Rezoning Transportation Analysis

Petition Number: #2022-082

Date	Description
11-28-22	First Review (TM)

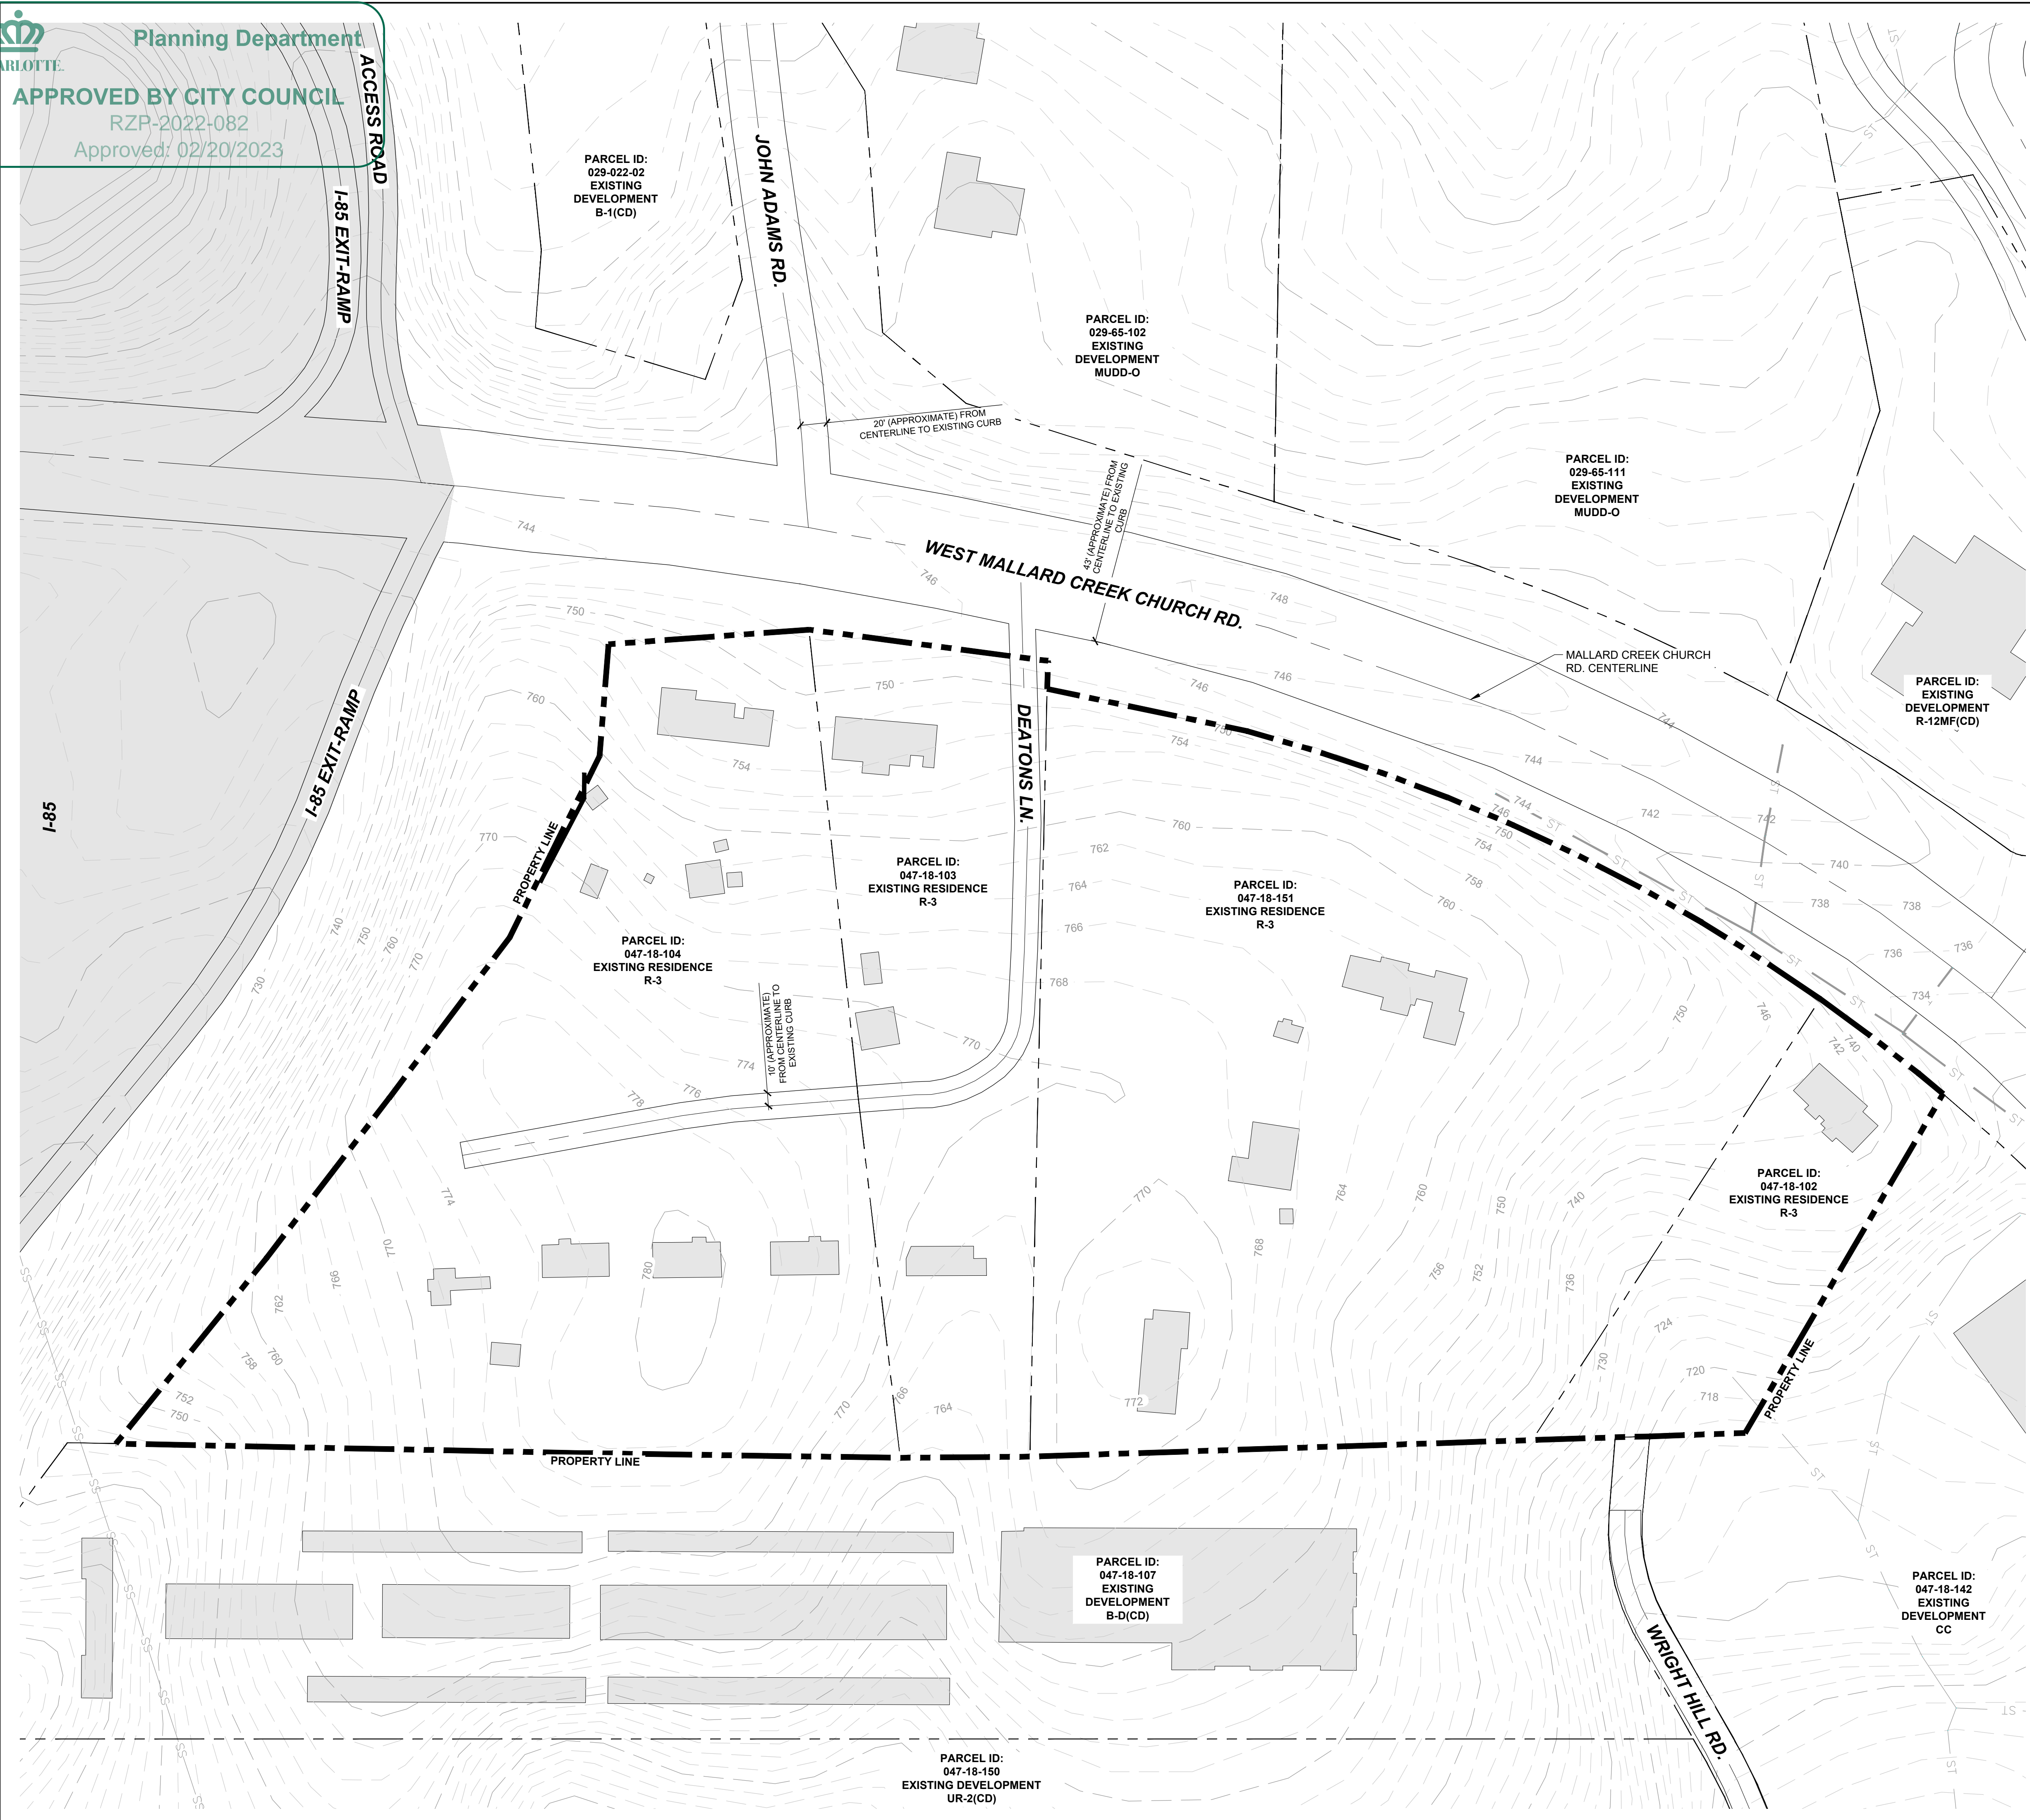
1. **Curbline:** The proposed zoning district has a setback measured from back of the existing or proposed future curblines.
 - a. **Mallard Creek Church Road:** The future location of curb and gutter is measured at 33-feet from the centerline of the roadway to the BOC.

Label and dimension the curb and gutter from the centerline for each road on the site plan.

6. Site plan and conditional note(s) revisions are needed to commit to construct bicycle facilities by locating the curb and gutter 33-feet from the center line and installing a 12' multi-use path on Mallard Creek Church Road to meet the City Charlotte BIKE Policy. Additional space may be required due to 33-feet not accounting for turn lanes and intersection dimensions.

7. Site plan and conditional note(s) revisions are needed to remove the proposed left over from the site plan. Per NCDOT comments, this movement will not be permissible.

8. Site plan and conditional note(s) revisions are needed to commit to aligning proposed Wright Hill Roadway extension to become a 4th leg at the intersection of Mallard creek and Mallard Glen Drive.

9. Site plan revisions are needed to show existing infrastructure along Mallard Creek Road, Wright Hill Road and Berkley Place Drive. Dimension all infrastructure from the roadway centerline and callout on site plan.
